## City of Albuquerque Stormwater Construction Site Inspection Report

General Information					
ESC File No.	A14E019	Project Name:	Dutch Brothers 528 - Work Order & Tract 2		
NPDES Id. No.	NMR1004R9	Location:	3615 HWY 528		
7/21/2023	Owner		Contractor		
Operator	Western Hills Real Estate/Development				
Contact name & title	Julian Garza				
e-mail	<a href="mailto:rio7712@aol.com">rio7712@aol.com</a>				
Contact Phone #	505-269-1179				
COA Inspector	Chancellor English		Start/End Time:	11:30AM	
Construction Phase:	final inspection -grading and sidewalk incomplete				
Type of Inspection:	<input checked="" type="checkbox"/> Regular	<input type="checkbox"/> Storm Event	<input type="checkbox"/> Post Storm Event >0.25"	<input type="checkbox"/> 311/Complaint	<input type="checkbox"/> Follow Up
Weather at time of inspection?	Clear		Temperature: ~	95	
Estimated date of last storm 0.25" or greater	5/22/2023

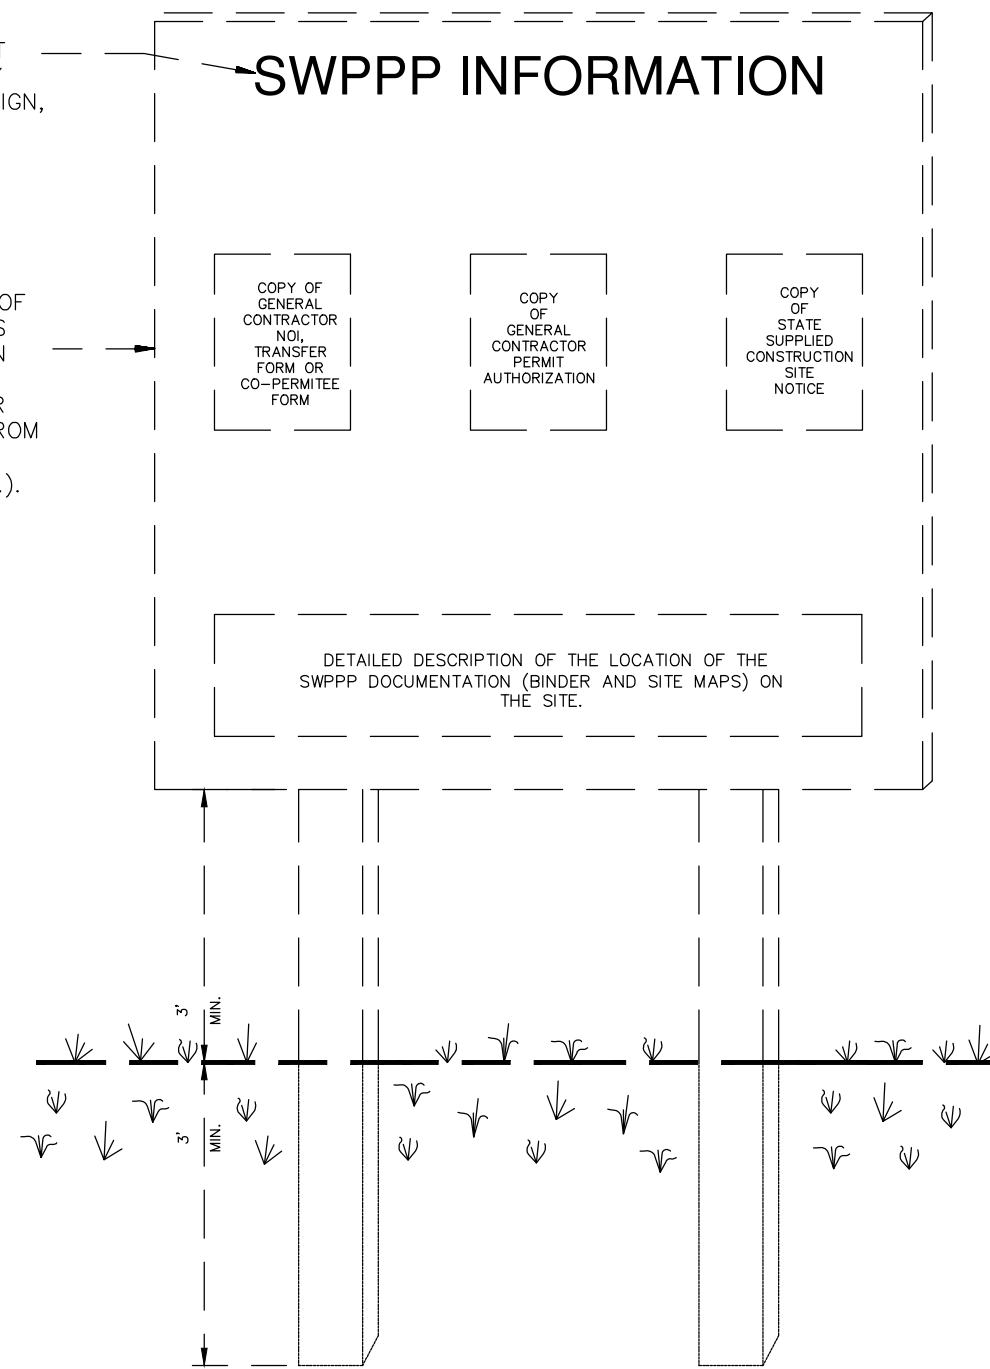
Item Number	Deficiency/ Corrective Action				
1	Permit coverage wasn't posted. You must post a sign or other notice of your permit coverage at a safe, publicly accessible location in close proximity to the construction site. The notice must be located so it is visible from the public road that is nearest to the active part of the construction site, and it must use a font large enough to be readily viewed from a public right-of- way per CGP 1.5				
2	SWPPP wasn't available on site at time of inspection, so it couldn't be checked to see if it is up-to-date. - Provide a scanned copy of the up-to-date SWPPP with all reports to the Storm Water Quality Section at 600 2nd St NW suite 400 - Jhughes@cabq.gov - Per CGP 4.8.2				
3	In accordance with City Ordinance § 14-5-2-11(C)(1), self-inspections must continue until the site is "determined as stabilized by the city." The property owner/operator is responsible for determining when the "Conditions for Terminating CGP Coverage" per CGP Part 8.2 are satisfied and then for filing their Notice of Termination (NOT) with the EPA. Each operator may terminate CGP coverage only if one or more of the conditions in Part 8.2.1, 8.2.2, or 8.2.3 has occurred. After filing the NOT with the EPA, the property owner is responsible for requesting a Determination of Stabilization from the City.
